KIRKLEES METROPOLITAN COUNCIL INVESTMENT & REGENERATION SERVICE

DELEGATED DECISION TO DETERMINE PLANNING APPLICATION FOR ADVERTISEMENT CONSENT

Reference No:	2026/64/92405/W
Site Address:	Yorkshire Building Society, 4, Market Place, Southgate, Honley, Holmfirth, HD9 6NY
Description:	Advertisement Consent for erection of digital tv screen on metal framework within shopfront window bed (within a Conservation Area)
Recommending Officer:	Dhruv Gopalakrishnan

Proposed Shopfront Section AA.
Scale 1:20

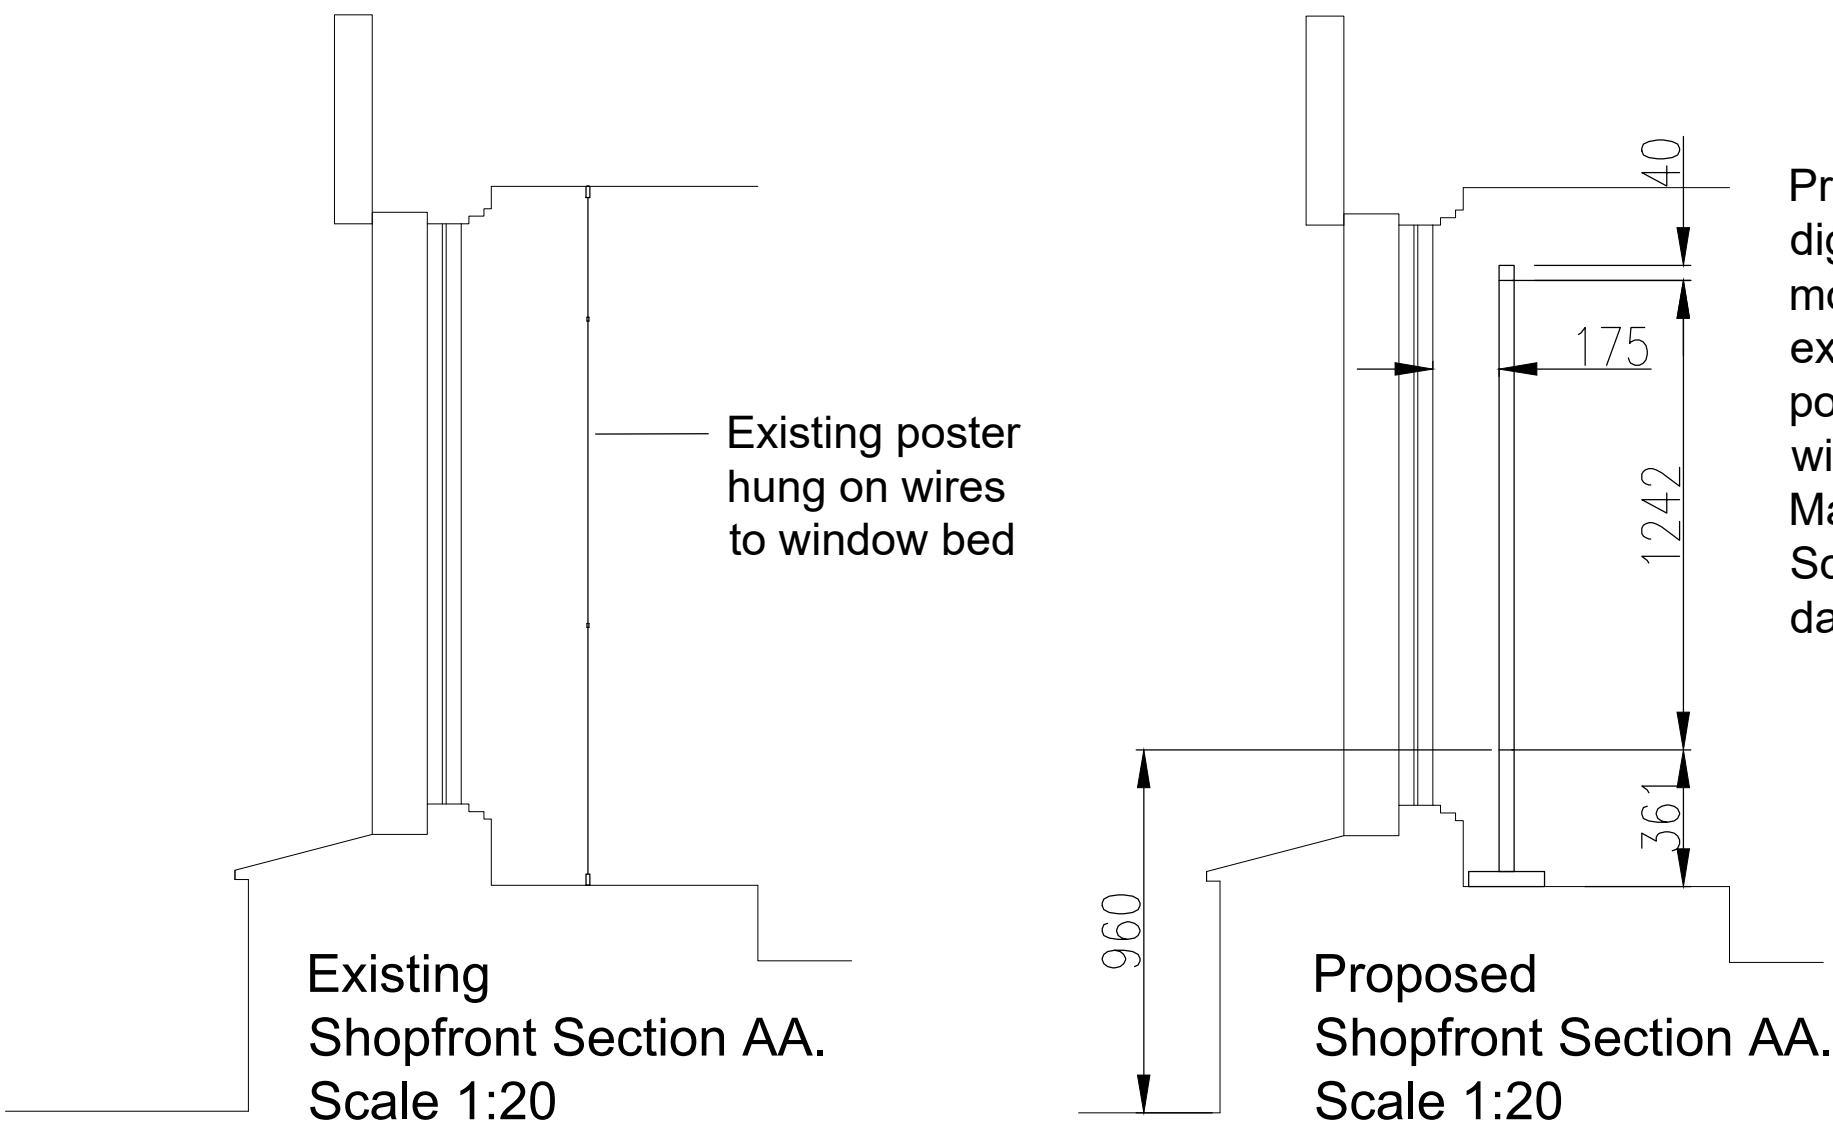
Following consultation with Kirklees Council Conservation and Design, the agent was recommended to increase the setback of the advert from the shop window to 300mm as opposed to 150mm as described in the original plans. The agent agreed to implement this recommendation and provided additional plans displaying a 300mm setback from the shop front window.

In response to comments received the applicant was recommended to amend the proposal. The setback of the advertisement from the shopfront window was increased from 150mm to 300mm. This amendment was sought to lessen the visual prominence of the display and ensure it integrates more comfortably within the surrounding street scene.

8. The hereby approved sign shall be set back a minimum of 300mm from the shopfront window.
